From: Simon Davis
Sent: 14 April 2021 16:32
To: Alex Burrows [REDACTED]
Subject: RE: BR/8/21/RES

Re: 224 London Road, Bognor Regis – BR/8/21/RES

From: Simon Davis <Simon.Davis@arun.gov.uk>
Sent: 08 April 2021 14:09
To: Richard Stefanski [REDACTED]
Cc: Alex Burrows [REDACTED]
Subject: RE: BR/8/21/RES

Drawing Title:  
**PROPOSED FLOOR PLANS**

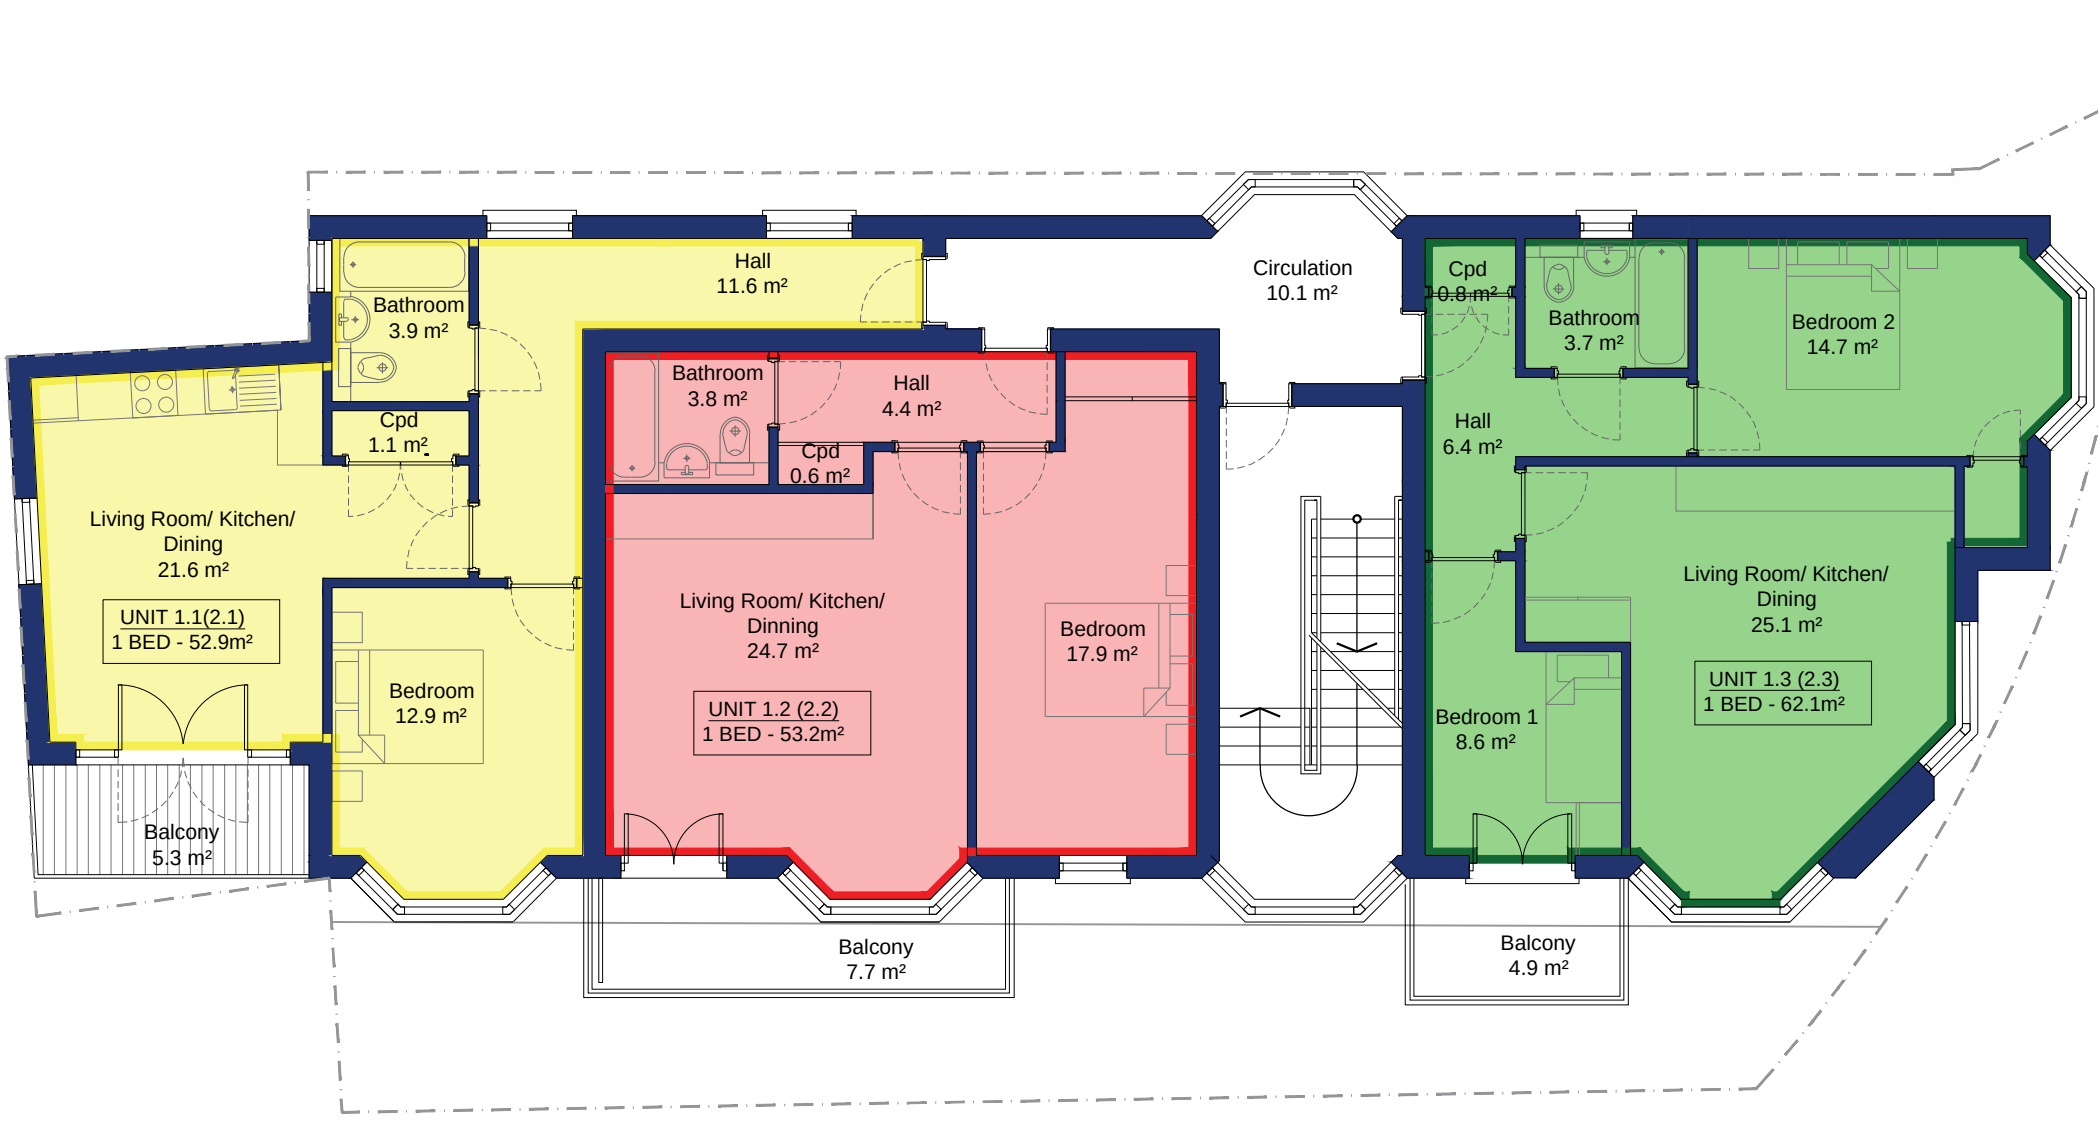
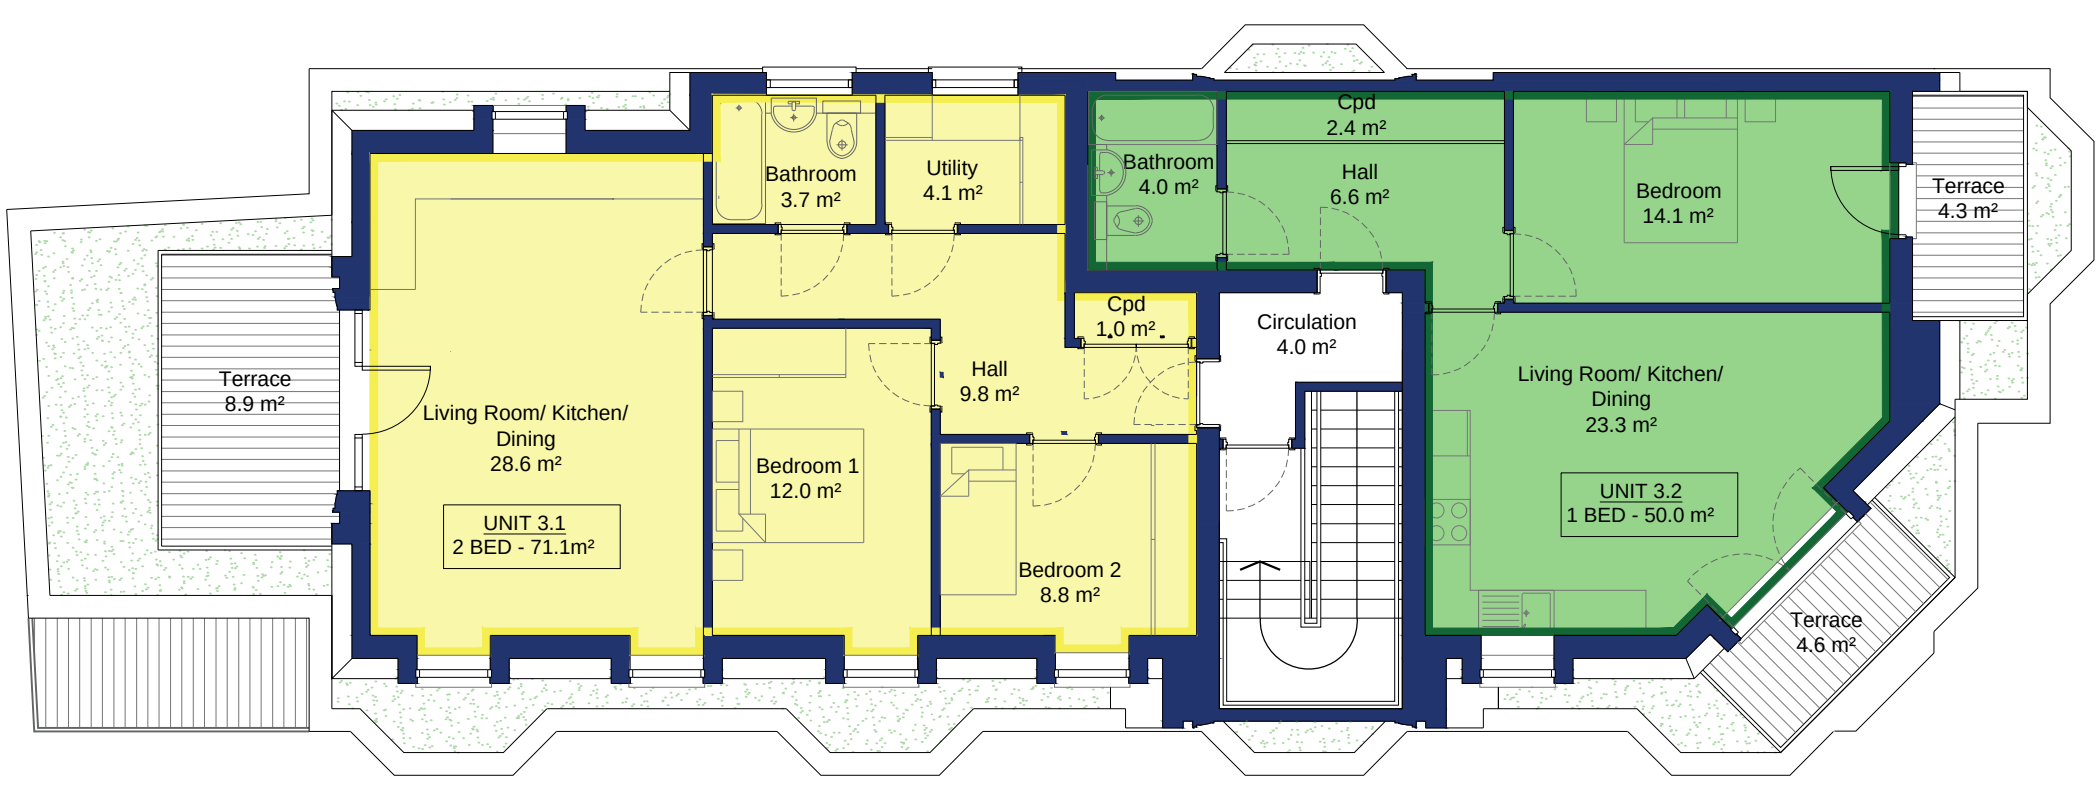
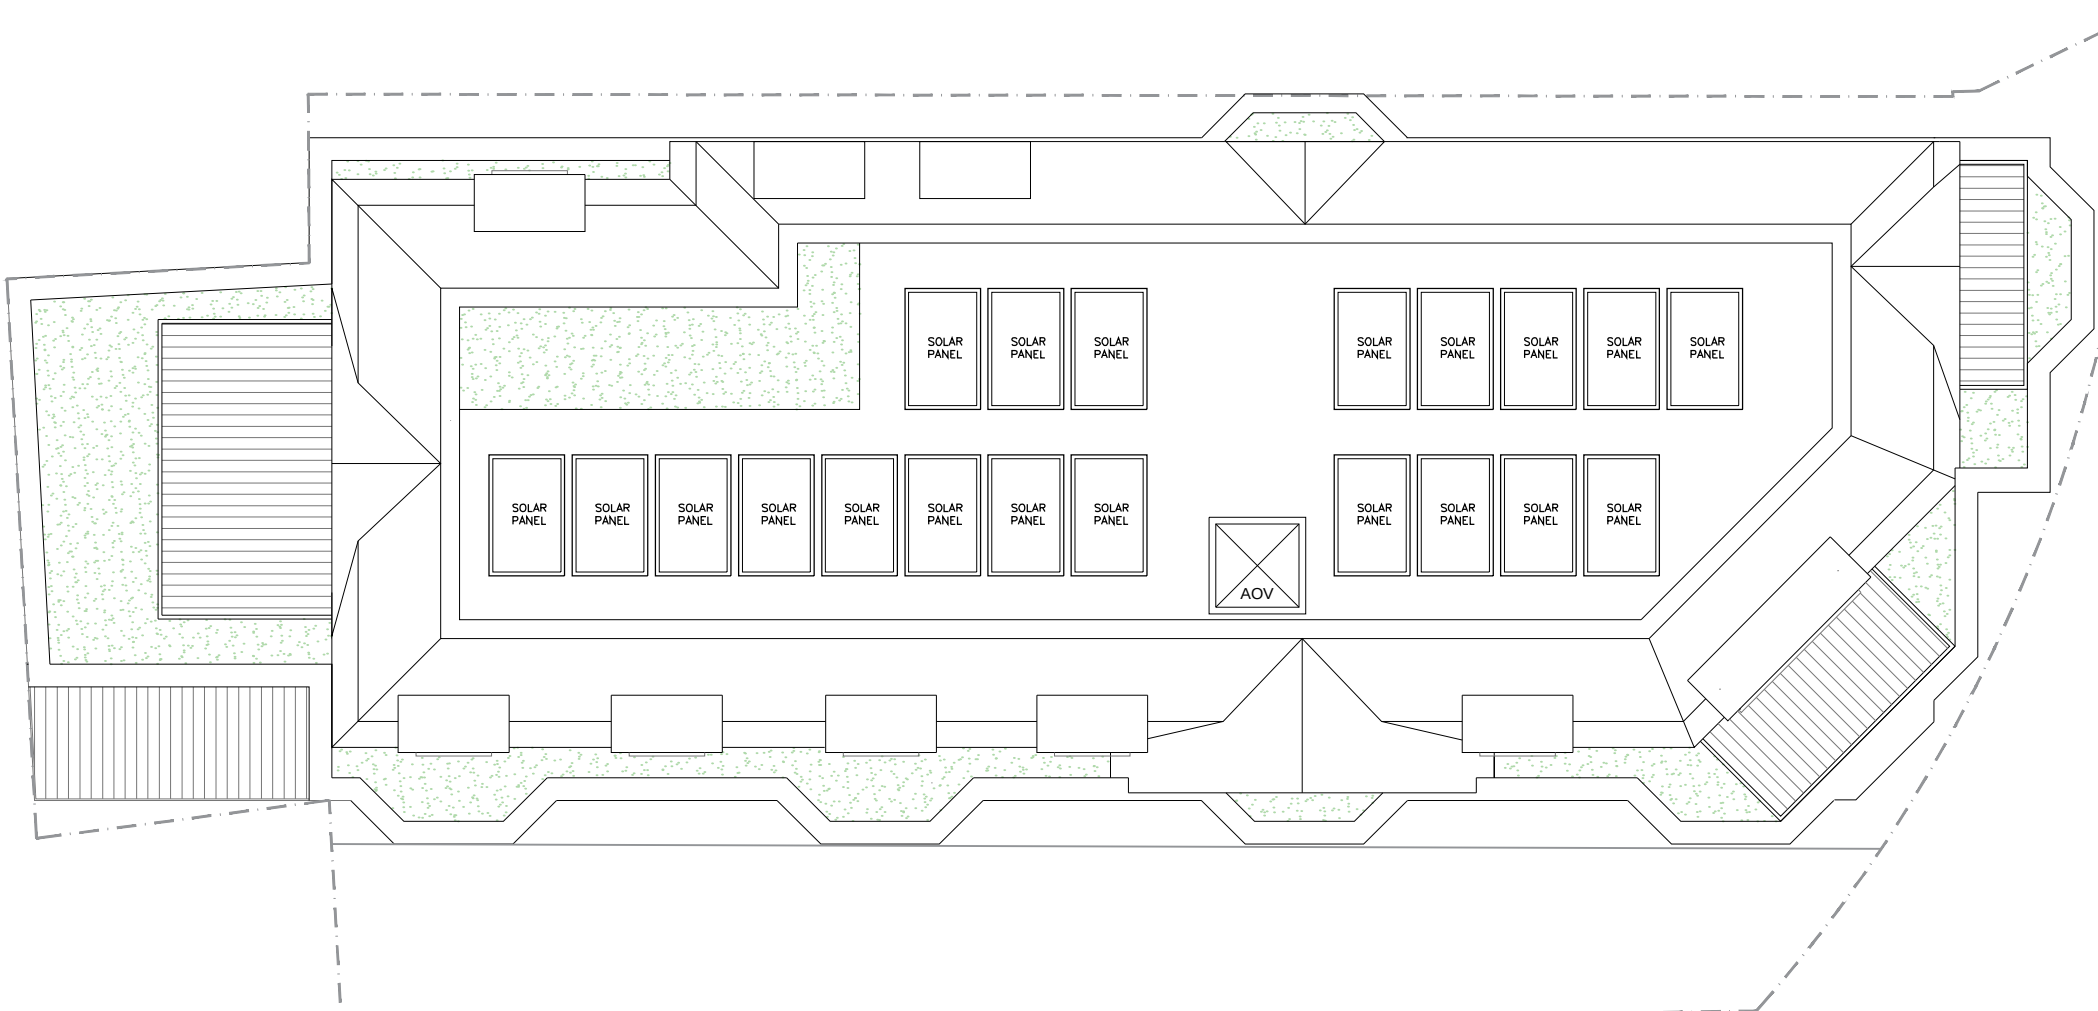
Our concern is with the height/scale and design of the proposed building. The Outline was for up to 10 flats over a max of 3.5 storeys but we did not give any indication at that time that such a scheme would be acceptable and indeed our members expressed serious concerns at Committee regarding 3.5 storeys/10 flats. We consider that the proposal will be out of character with its surroundings (noting that the

predominant existing form of development is two storeys) and that the proposal could also result in harm to the two nearby heritage assets (signal box & railway bridge).
